# PLOT PLAN

(THIS IS NOT A PROPERTY SURVEY)  
8778 BITTERCRESS DRIVE

SFD211707  
PLAT 14663  
RS-6000 CAD-0

**PLOT PLAN**  
(THIS IS NOT A PROPERTY SURVEY)  
8778 BITTERCRESS DRIVE

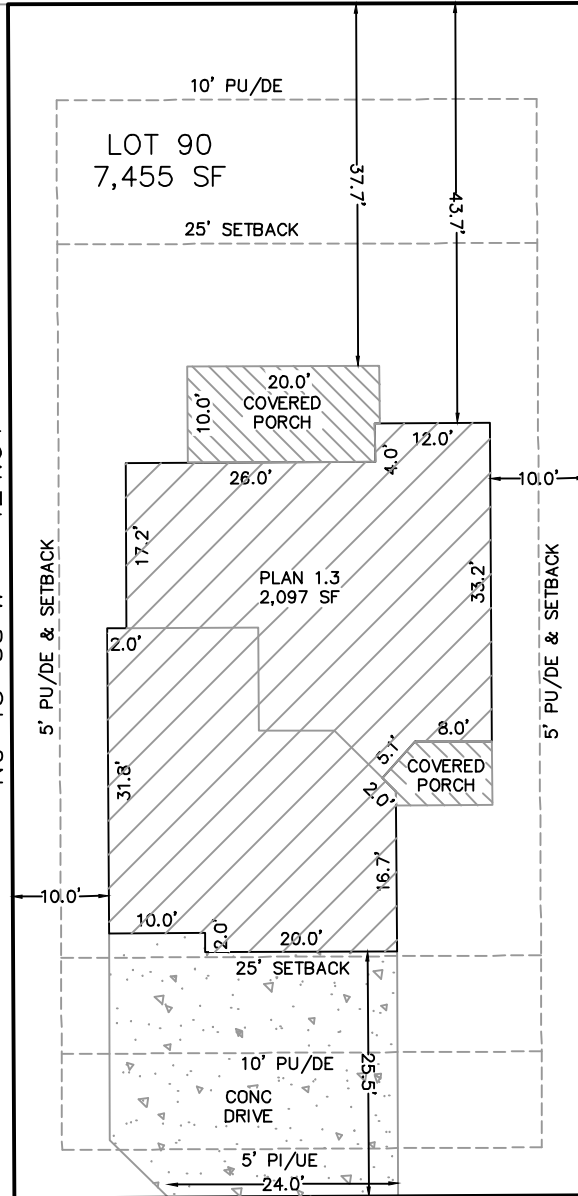
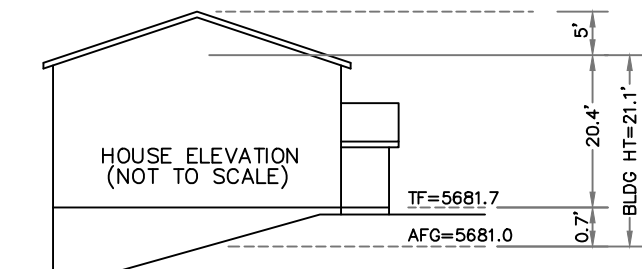
No basements per preliminary plan hazards TRACT B
